Land at Drove Lane, Yapton
Surface Water Drainage Statement Addendum

(Document ref. 133647-SWDS-01C)

This updated addendum is to be read in conjunction with Document Reference: 133647-SWDS-01A and all relevant drawings to support the reserved matters application for the development site at Drove Lane, Yapton.

Granular Blanket Below Detention Basin
Pond 2

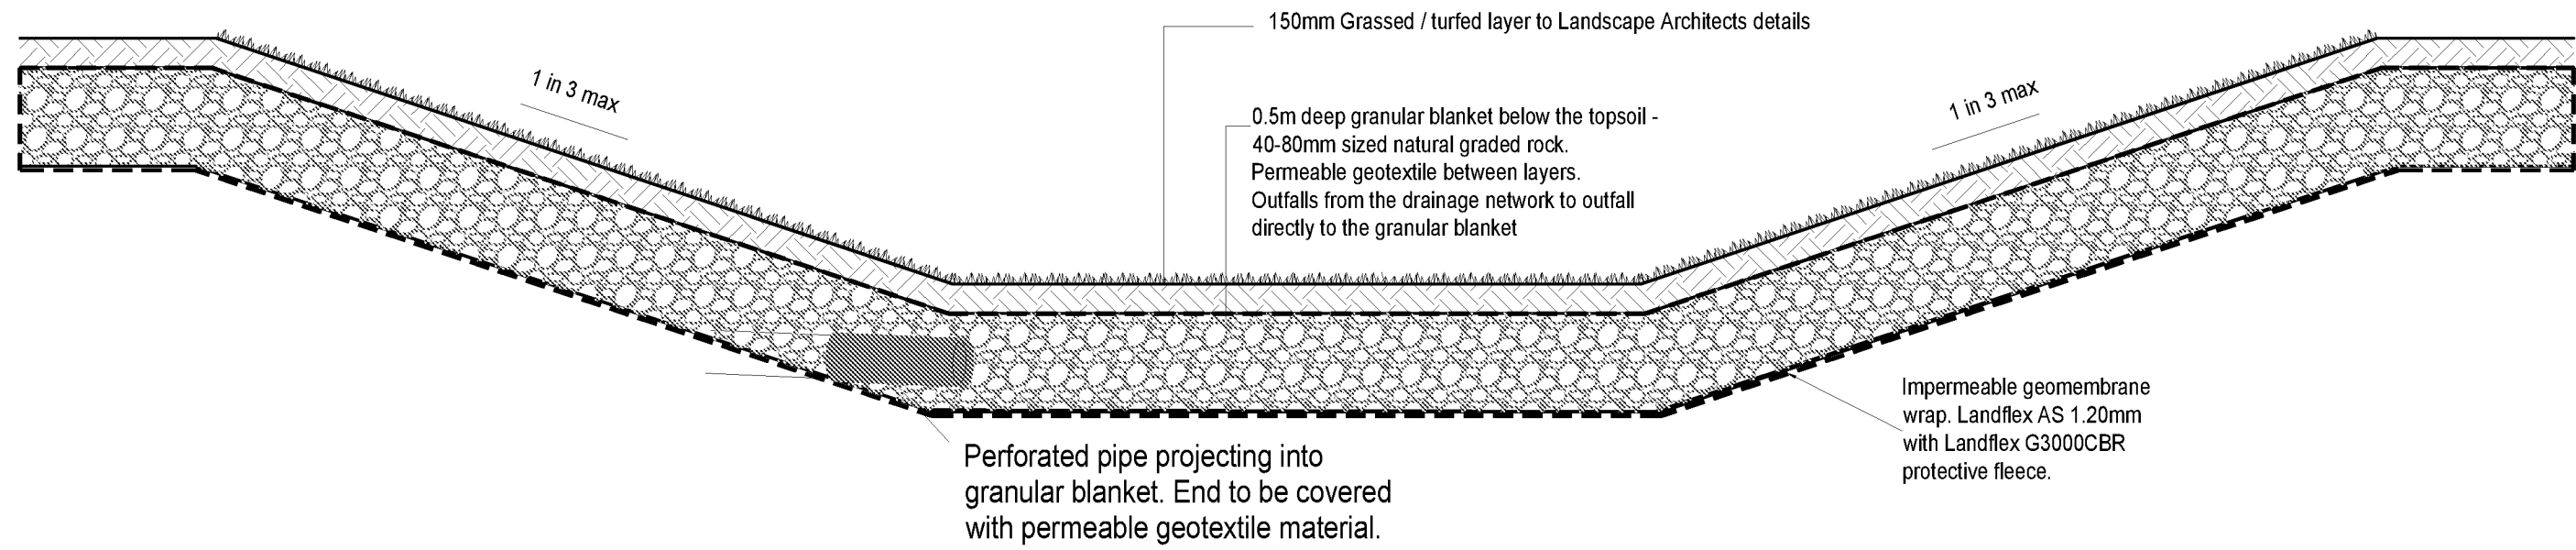
- Orifice details have been added to the drainage construction details.
- Pond 2 is not lined. All features that are below the worst case ground water level from the winter monitoring have sufficient permeability to allow water to ingress and egress.

Section Through Outfall Into Existing Ditch

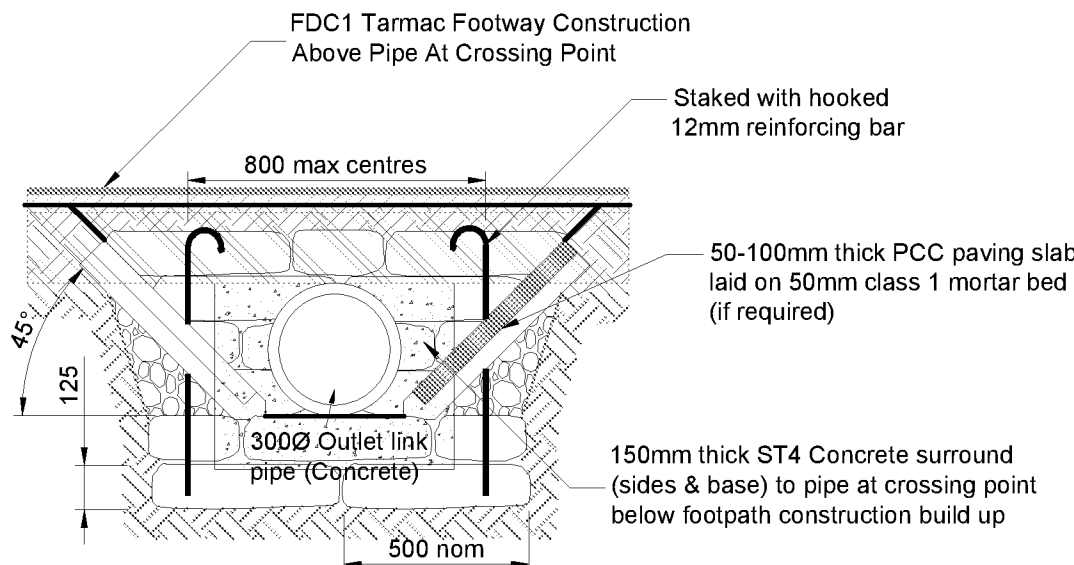
- The connection to the water course is now shown.
- Chainages are shown on the sections for the SuDS features, we do indicate the berms, top and bottom of bank, maximum water level and freeboard. Please refer to the specific SuDS details for material and crates beneath the ponds. They are drafted at a clearer scale to show the increased level of detail.
